State of Washington  
DEPARTMENT OF FISH AND WILDLIFE

SUBJECT: WDFW COMMENTS ON RU-26-00001 Pazaruski

Thank you for the opportunity to review and comment on Kittitas County Reasonable Use Application RU-26-00001 Pazaruski, a proposal to construct a 992 square foot residence, 600 square foot detached garage, driveway/access improvements and the installation of a culvert crossing on Kittitas County parcel 558535. The Washington Department of Fish and Wildlife (WDFW) is familiar with this parcel and has previously been on site (2018) to review the streams on the property. Our comments are regarding the project's impact on Fish and Wildlife Habitat Conservation Areas (FWHCAs, CAO Chapter 17A.04), specifically stream and riparian habitat.

LOT 9 HYAK ESTATES 2 GRADING DESIGN
RYAN PAZARUSKI
SITE PLAN

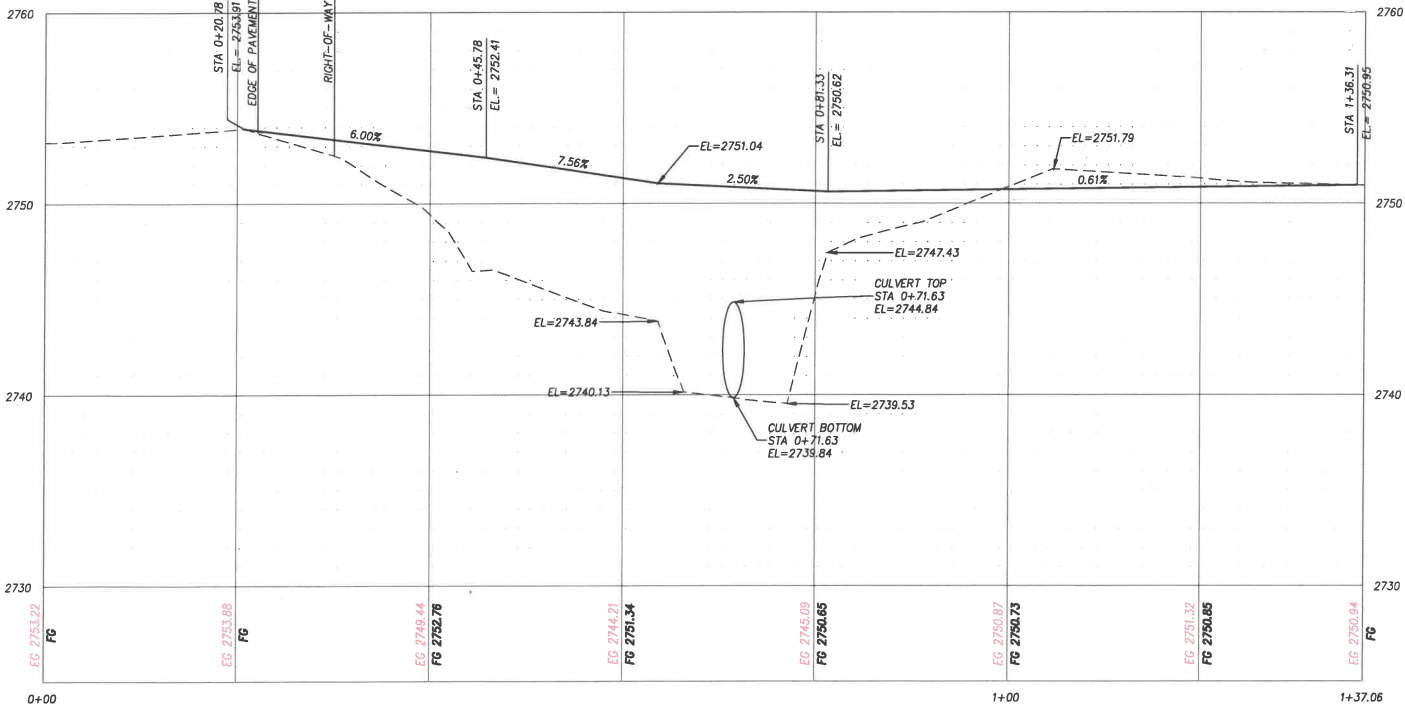
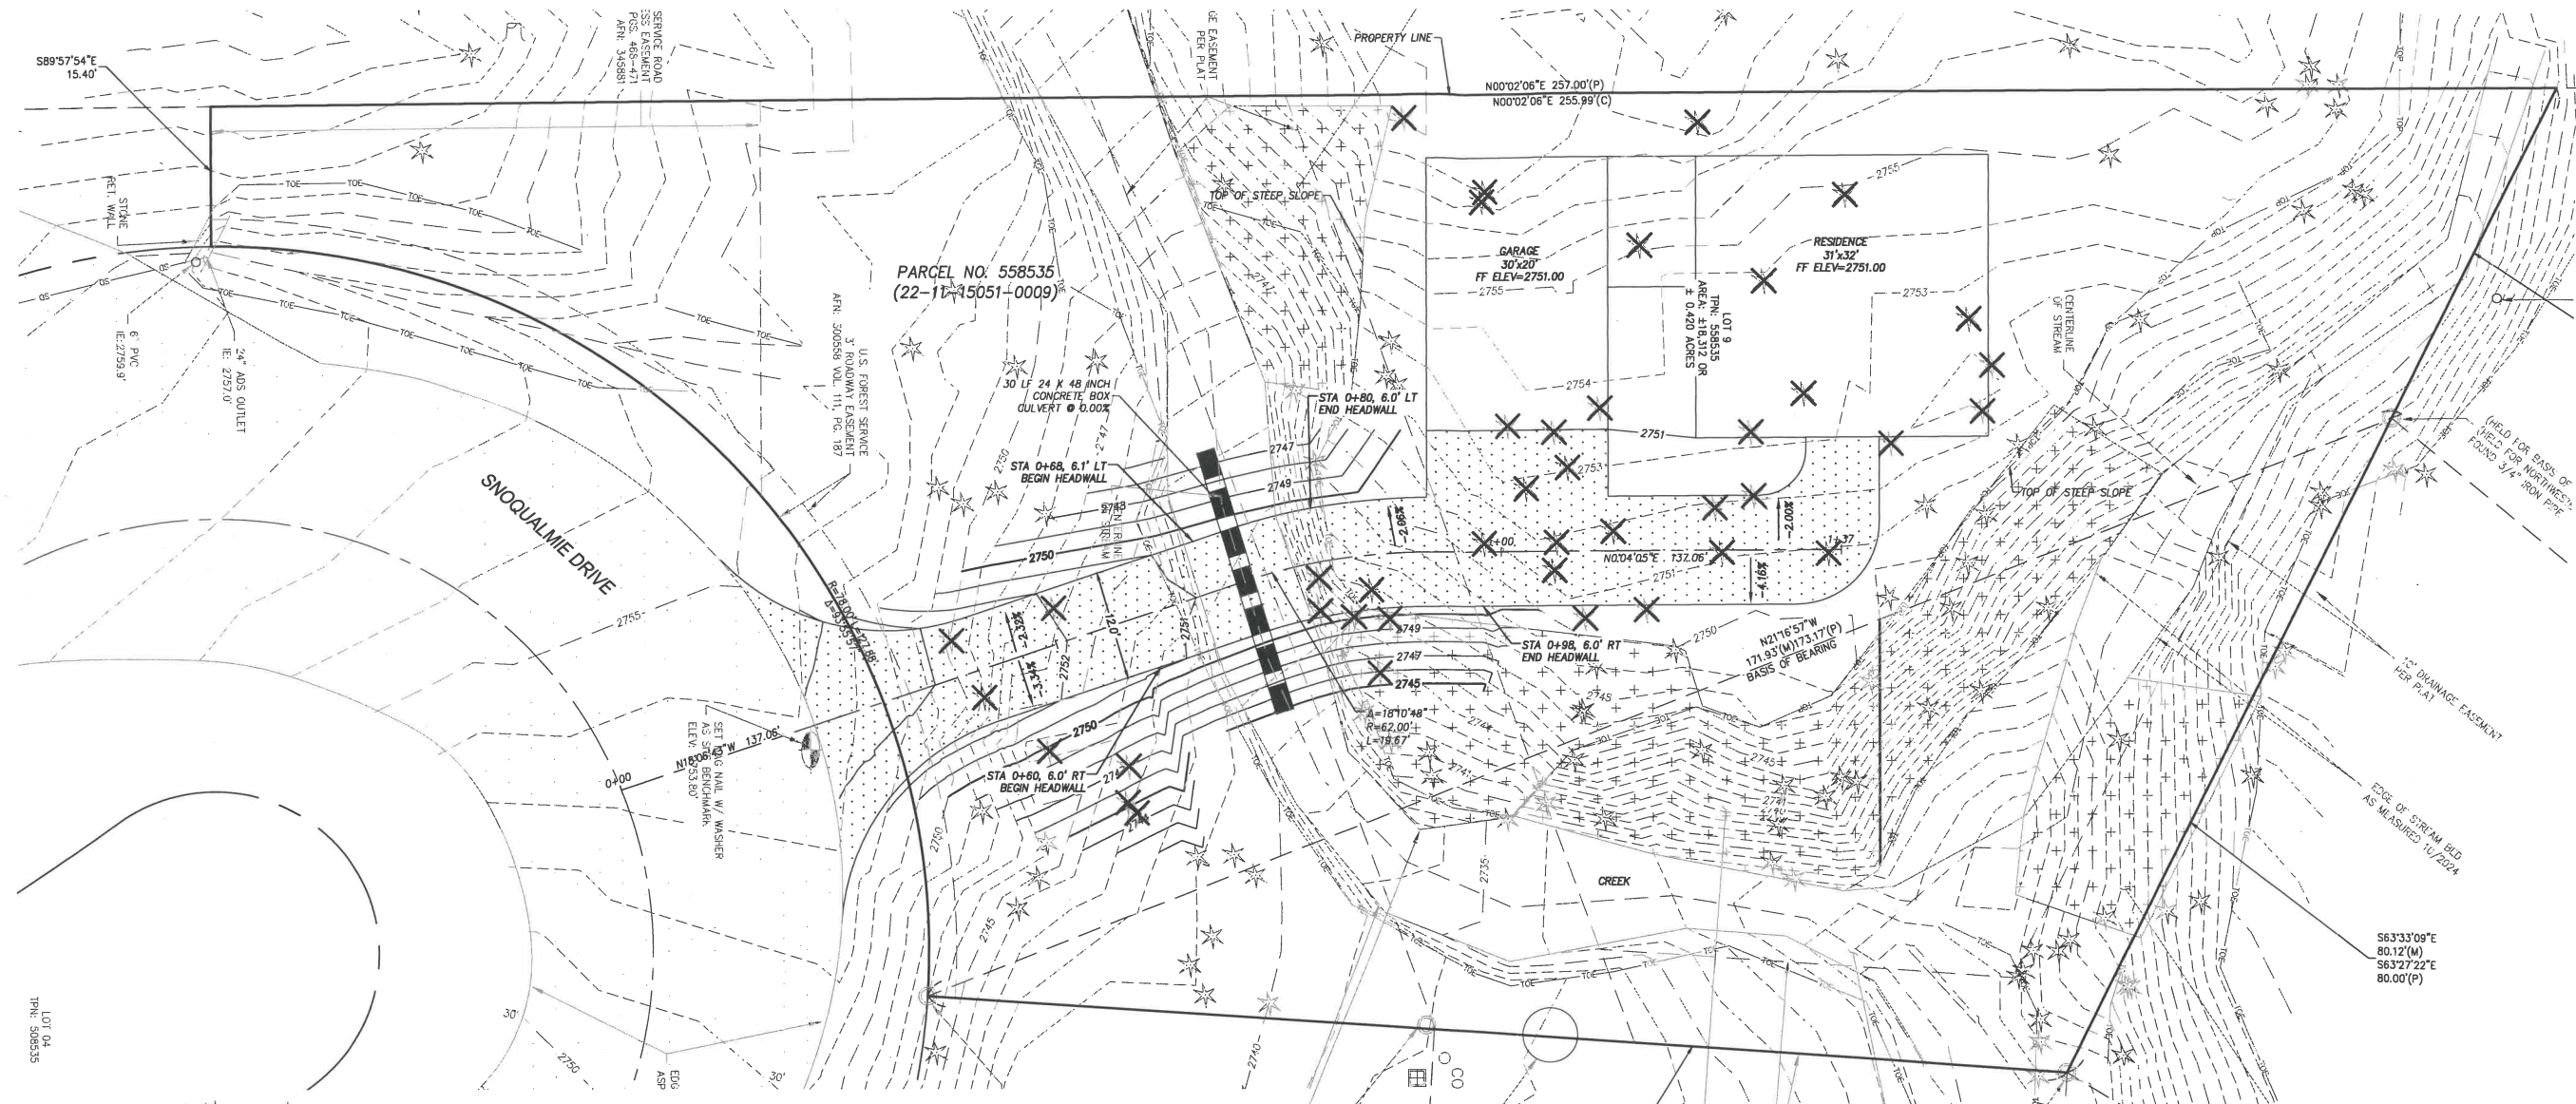
The proposed project is wholly within the Riparian Management Zone (RMZ, CAO 17A.04.030) of the streams. Kittitas County's Critical Areas Ordinance (CAO) states that RMZs and buffers shall be maintained in a predominately well-vegetated and undisturbed condition to ensure that they perform their intended function of protecting the FWHCA. Further, Riparian is identified as a Priority Habitat under WDFW's Priority Habitat and Species Program.

Under Kittitas County's CAO, the RMZ width shall be either the site-specific Site Potential Tree Height (SPTH) or 100 feet, whichever is greater, consistent with Best Available Science for pollution removal and Volume 2 of WDFW's Riparian Ecosystem Management Recommendation (CAO 17A.04.030(2)). Using the [SPTH mapping tool](#), the RMZ buffer at this location is 126 feet from the ordinary high water mark (OHWM).

We recommend following the mitigation sequencing of avoidance, minimization and mitigation. Avoiding and minimizing impacts to the RMZ as much as possible by reducing the development footprint as feasible and siting the infrastructure as far away from the streams as possible. Where impacts cannot be avoided, compensatory mitigation will be needed to offset the impacts to the streams' riparian buffers.

The proposed stream crossing will need to meet [WAC 220-660-190](#) and will require a Hydraulic Project Approval (HPA) permit from WDFW prior to construction. The water crossing structure must be designed to pass the 100-year flood flow, including ice, large wood and associated debris. During a site visit in October 2018, WDFW reviewed a potential access road for this parcel, with access from Snoqualmie Drive, and took bankfull measurements of the stream. The bankfull width measurements ranged from 11-14 feet. Based on these measurements, the 48" culvert proposed on the site plan is not sufficient. Following WDFW's Water Crossing Design Guidelines and WAC 220-660-190, WDFW recommends a bridge. We request a site visit with the landowner to review the proposed stream crossing location and discuss the water crossing structure.

Given there are two streams on this small parcel, and the RMZs wholly encompass the parcel, the plan should also explicitly state how much of the riparian area is to be left. Significant incursions into the riparian area are likely to result in substantial impacts to the streams and avoidance and minimization should be the first step of this mitigation plan. We recommend the mitigation plan be developed prior to approval of this application to determine if the impacts could be mitigated for.
